Comment Correction Required / Response Report

Application No. PDZL-24-0005

P:\2024\24-1010_BLR_Village_C\Drawings\241010_BLR_Village_C_Land_Use_Plan.dwg 6/13/2025 10:27 AM

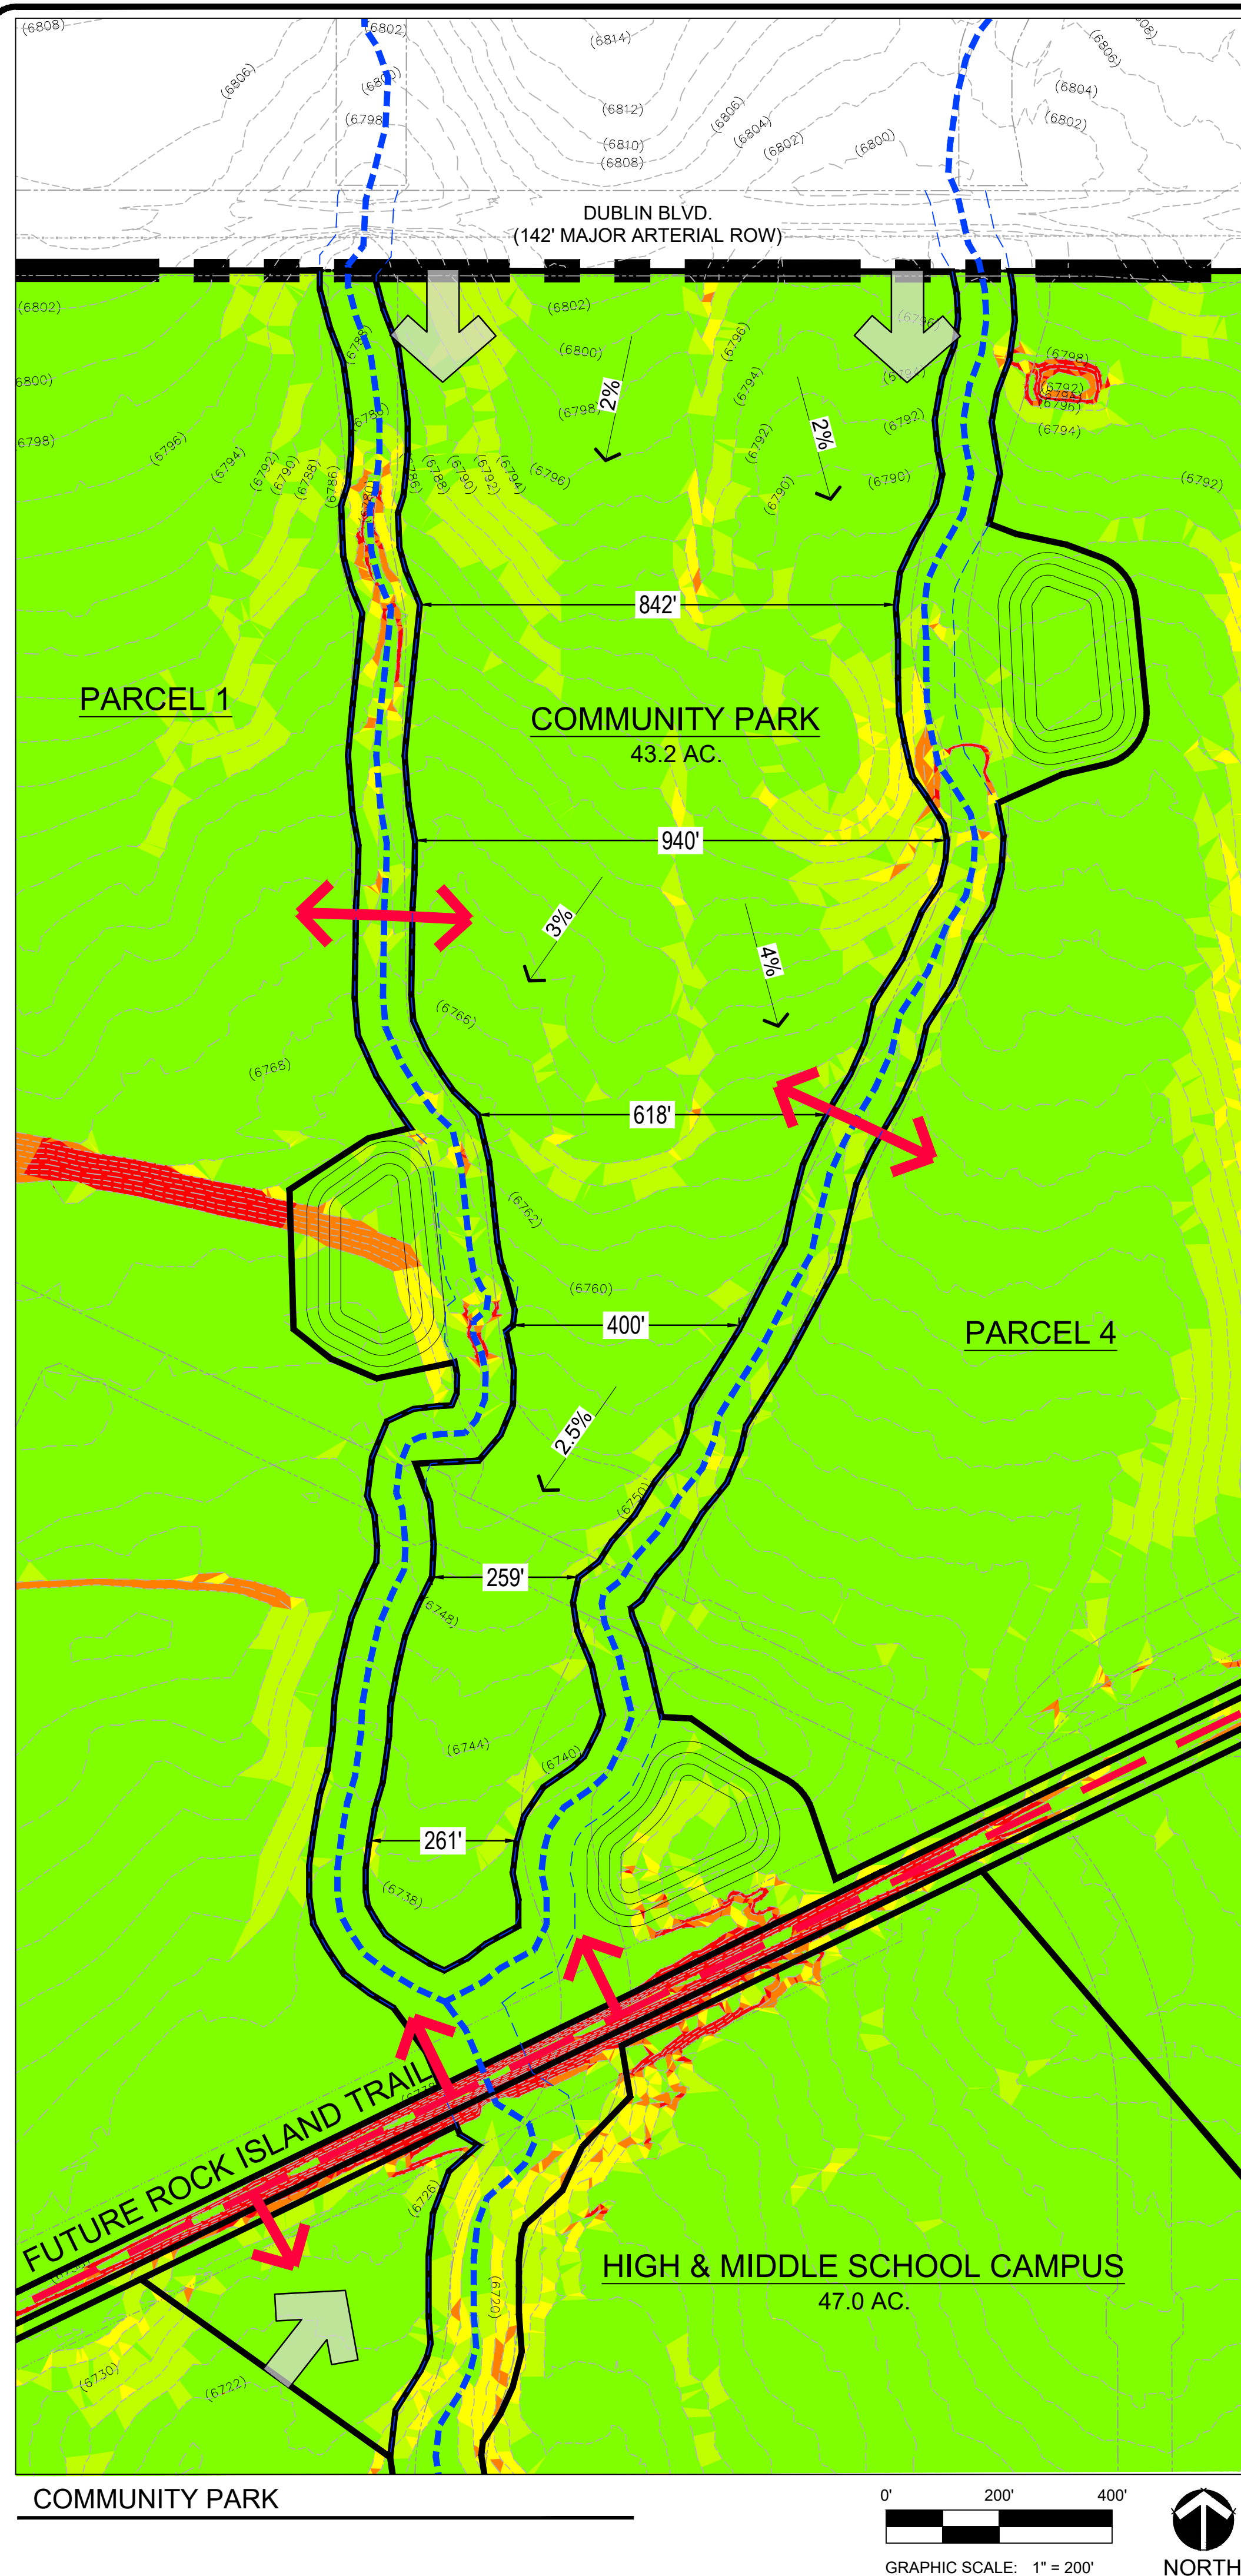
2	2	Note	Zaker Alazzeh : City Eng - Traffic Engineering	Open	1- The developer shall dedicate appropriate ROW along northern property line of Parcel 6 side at Dublin Blvd. This dedication must be consistent with the western property line ROW. 2- Please update the traffic study. Details are shown in the traffic impact study review comments.	RESPONSE: Please see included T.I.S comment response letters from S.M. Rocha dated March 26, 2025.
15	1	Free Text	Jonathan Scherer : City Engineering - SWENT	Open	Show and label all major drainageways on the vicinity map.	RESPONSE: Added.
16	1	Free Text	Jonathan Scherer : City Engineering - SWENT	Open	In the Floodplain Statement, include which flood zone the Site lies within (e.g. Zone X).	RESPONSE Added.
17	1	Free Text	Jonathan Scherer : City Engineering - SWENT	Open	The Site also appears to be located within Panel 08041C0561G. Please include within the Floodplain Statement.	RESPONSE Added.

45	2	Note	Caroline Miller : Planning	Open	Have there been considerations of moving the N.H. Park 3 east of the utility easements to serve the residential communities of Parcels 6, 7, and 8? It is still within a half mile of walking distance along the Rock Island trail which is park standard, but by vehicle park access is further. Phasing may also play a role in this.	RESPONSE We agree that there should be a park east of the utility easement. We have added a 4 th park to serve this area. We are projecting (4) 3.5 acre Neighborhood parks which exceeds the requirement projection of 12.151 acres.
46	2	Note	Caroline Miller : Planning	Open	As shown, there is a need for pedestrian bridges to allow connection to the Community Park site. Will the developer provide those?	RESPONSE Yes the developer will provide access over the drainageways to the community park. The type of crossing has not been determined.

54	2	Note	Caroline Miller : Planning	Open	Please add a note that the Rock Island Trail Corridor easements will be provided to the City at time of adjacent development.	RESPONSE: Rock island trail has an existing easement that varies in width 100-200'.
68	2	Callout	Tamara Baxter : Planning	Open	Please expand if 'dwelling - two family (duplex)' will also be allowed per UDC.	RESPONSE *Note has been added for clarification.
75	2	Callout	Tamara Baxter : Planning	Open	Refer to Staff comments on proposed PDZ zoning, not meeting eligibility for PDZ district. Conventional zoning is encourage. Thus, density for specific parcels make need to be updated.	RESPONSE: Zoning has been revised to R-flex Medium and MX-M per recommendation of planning staff.
